Job ID: 2012-05-4092-ALTCOMM

has permission to Construct a 12'x20' loading dock & 24'x6'4" concrete vehicle ramp on existing building, re-build adj..steps provided that the person or persons, firm or corporation accepting this permit shall comply with all of the provisions of the Statues of Maine and of the Ordinances of the City of Portland regulating the construction, maintenance and use of the buildings and structures, and of the application on file in the department.

Jeanie Bourke - RE: side step detail Plasmine

Entry Stairs

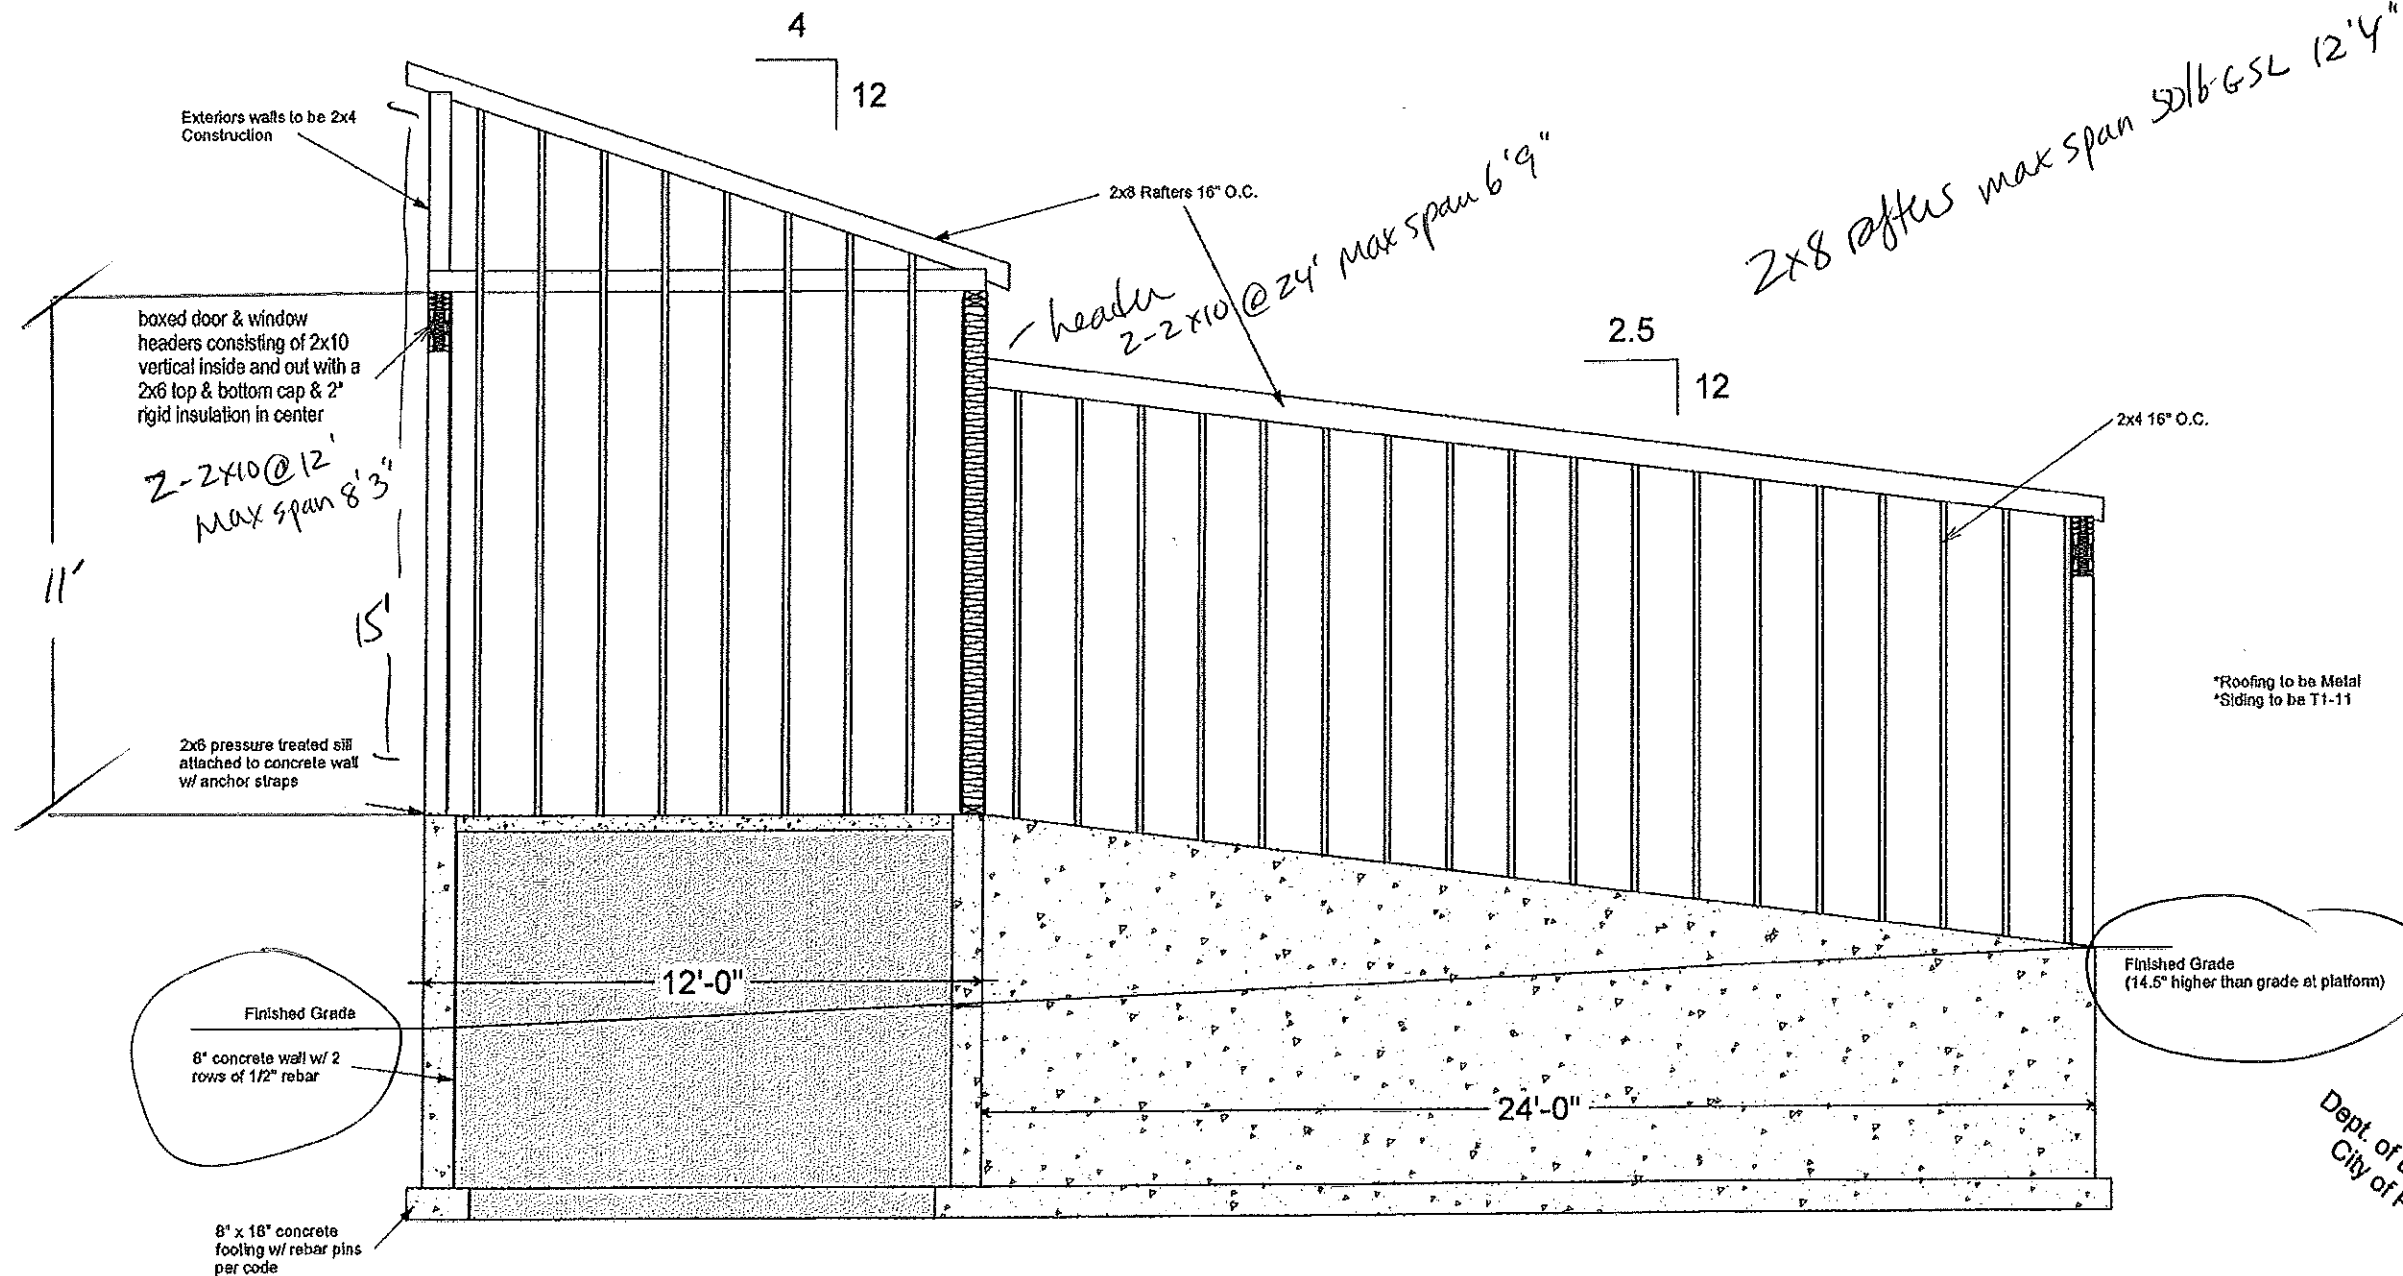
I would like the description labels to be complete...it is not clear what some say...
Thanks

Not to be picky Mark, but the descriptions are broken up.
Jeanie

If the stair is exiting from the industrial area, the toe kick is allowed up to 7". Graspable hand rails are always required on both sides of stairs with returns at 34"-38", with few exceptions.

Just remember the tread dimension is measured from tread nose to tread nose.

1. This is labeled as Plasmine Office Building, so is this business use or industrial? Reason being is that the landing is required to be at the level of the floor with some exceptions based on use, and business is not one of them.
2. The net tread is required to be 11" with no nosing projection, 90 degrees to the riser or an angled riser so an 11" seat cut.
3. Can you please provide more detail on the framing, ie. cross section showing beam size and bearing detail, joists and connectors.
4. Is the top rail on the stairs graspable and will there be another handrail on the wall?

I am not sure how you classify the use of this stairway, it is attached the warehouse/storage area of the office building. I would consider that industrial, no customers will be using this set of stair; it will be employee only entrance. The reason we had left the toe kick is because that is what they requested, but if we need to make it flush for code we will. Please let me know on that.

We were planning on using a 2x4 railing. I guess that is not considered "graspable" but we did not have plans of putting in a second rail. Again if we need to add a graspable rail, just let me know and we will.

I will have our architect draw the framing details and cross section and get that back to you. We can also make the total tread depth 11".
